ENG-SF18021-R4-CD-redlines.pdf Markup Summary

MATCHLINE ~ STA. 5+50.00
(SEE SHEET 5)

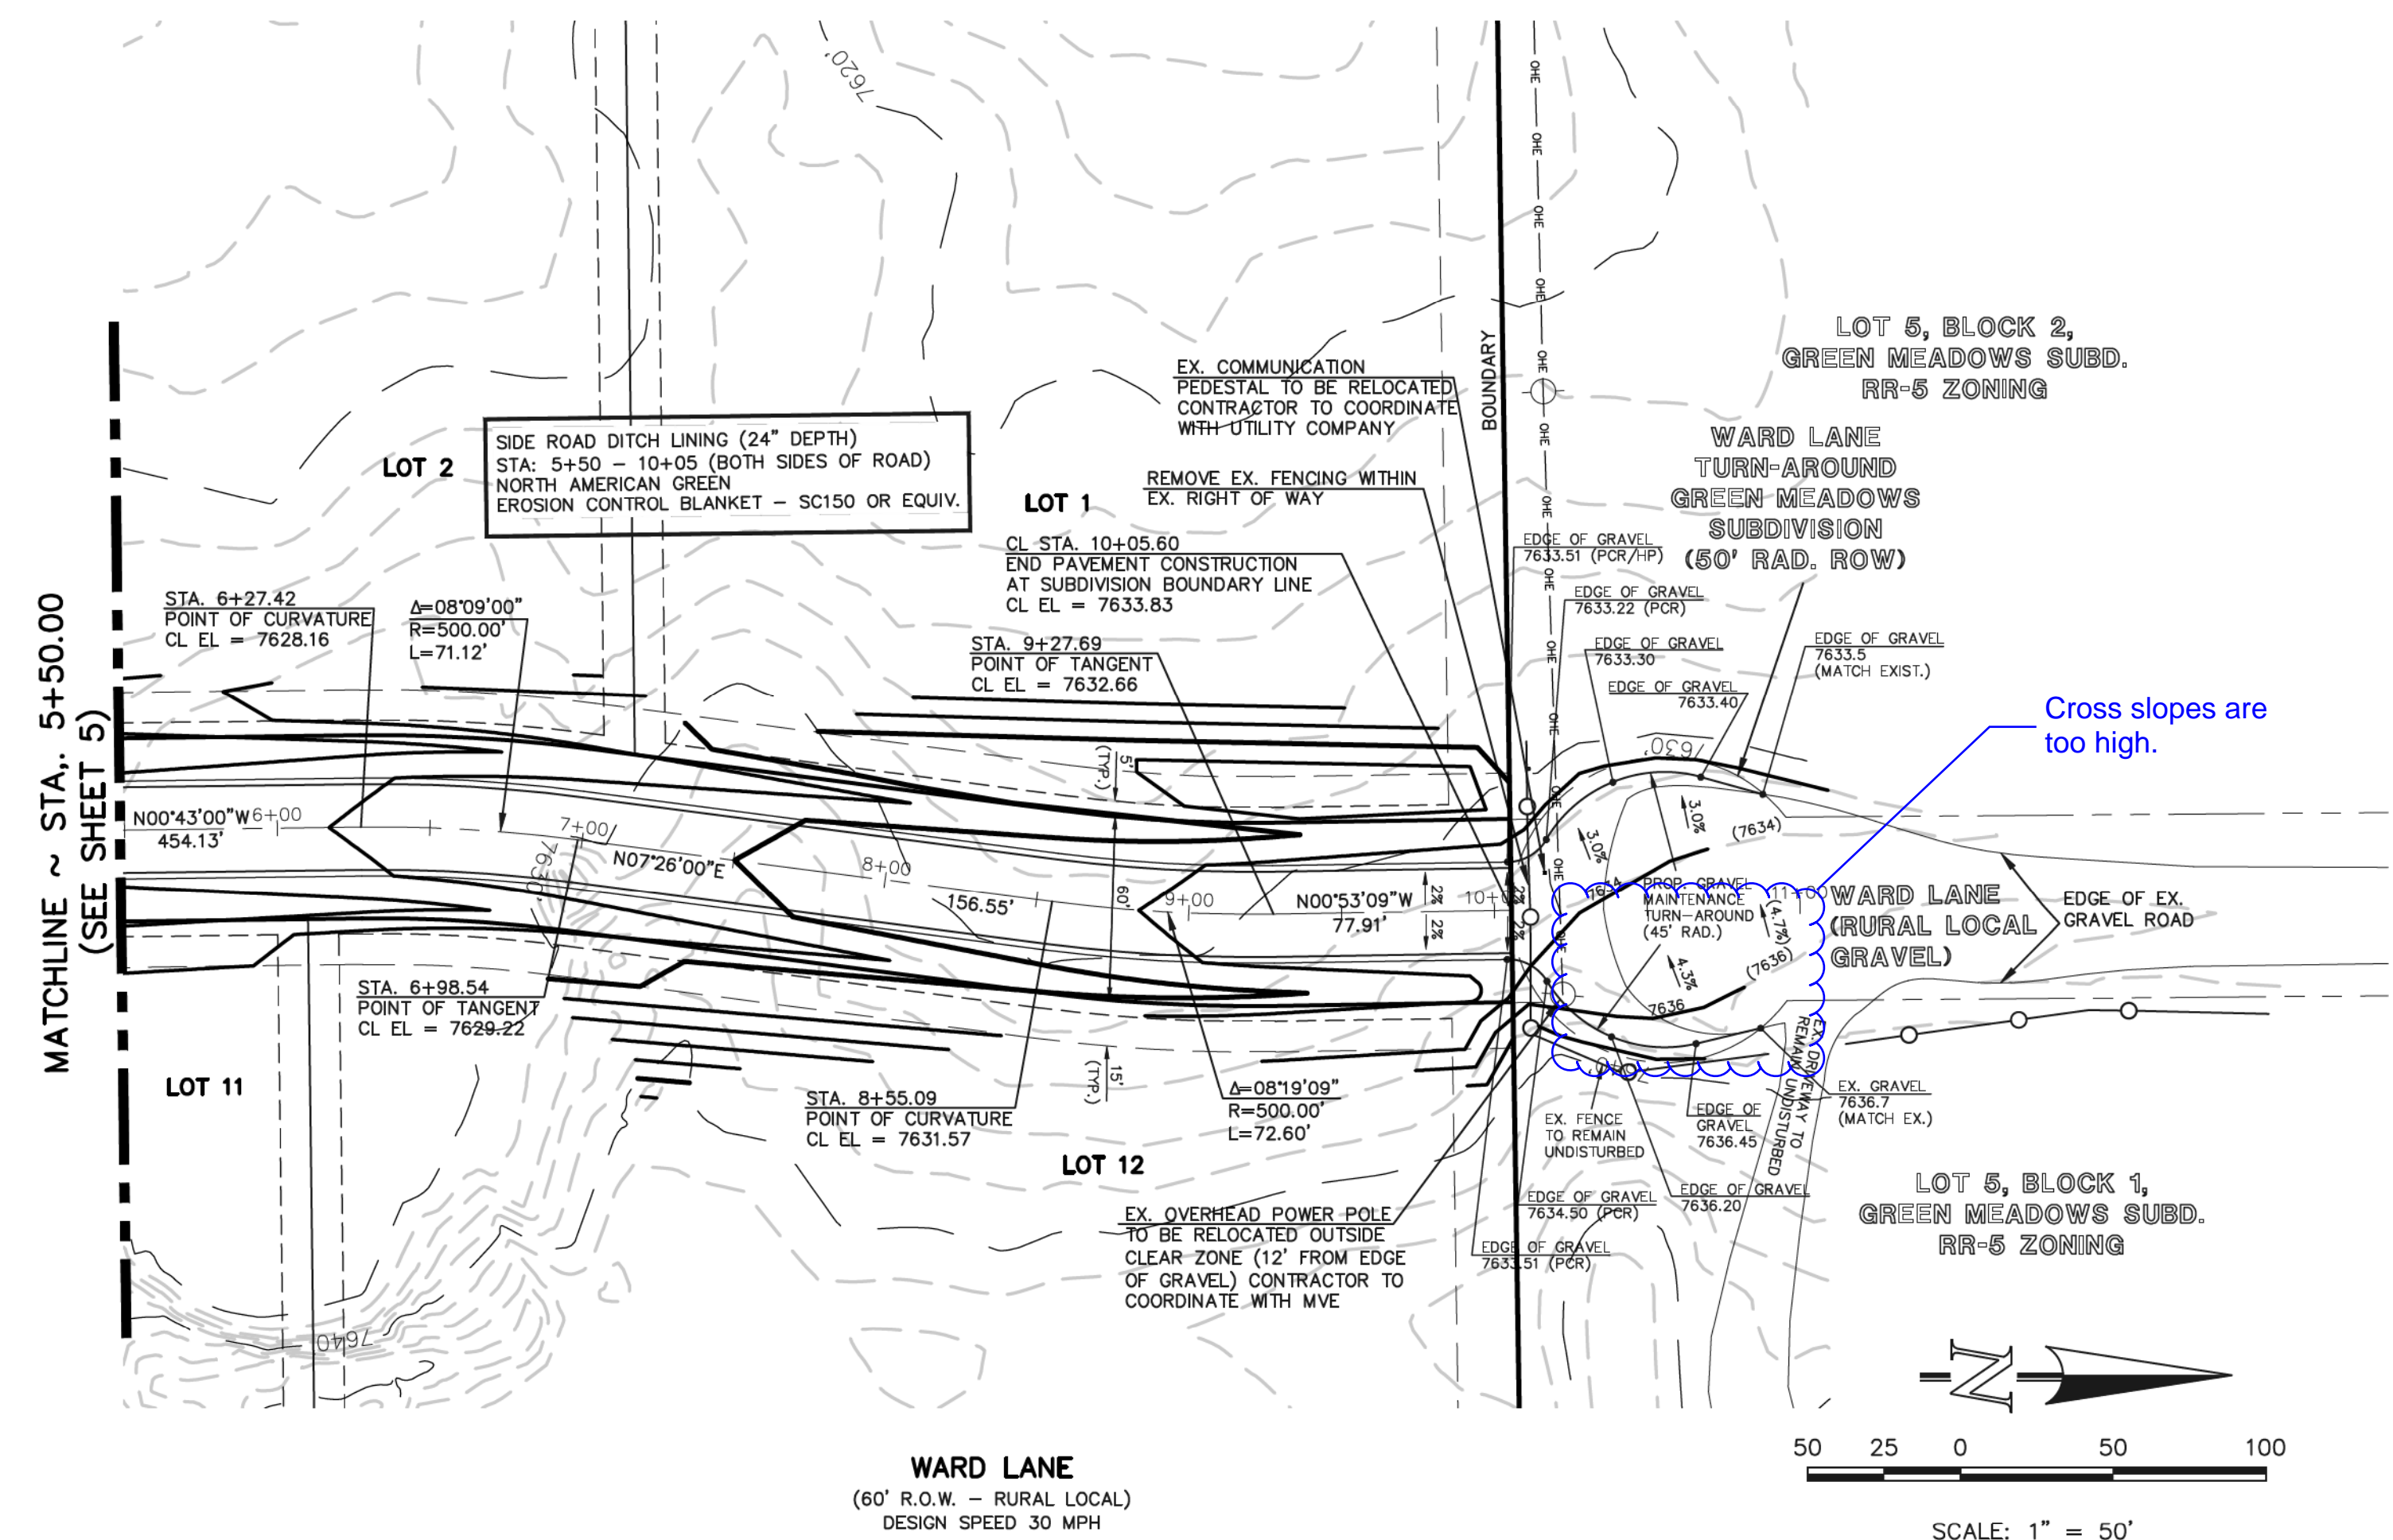
Cross slopes are too high.

Provide left and right EOP/EOG profiles.
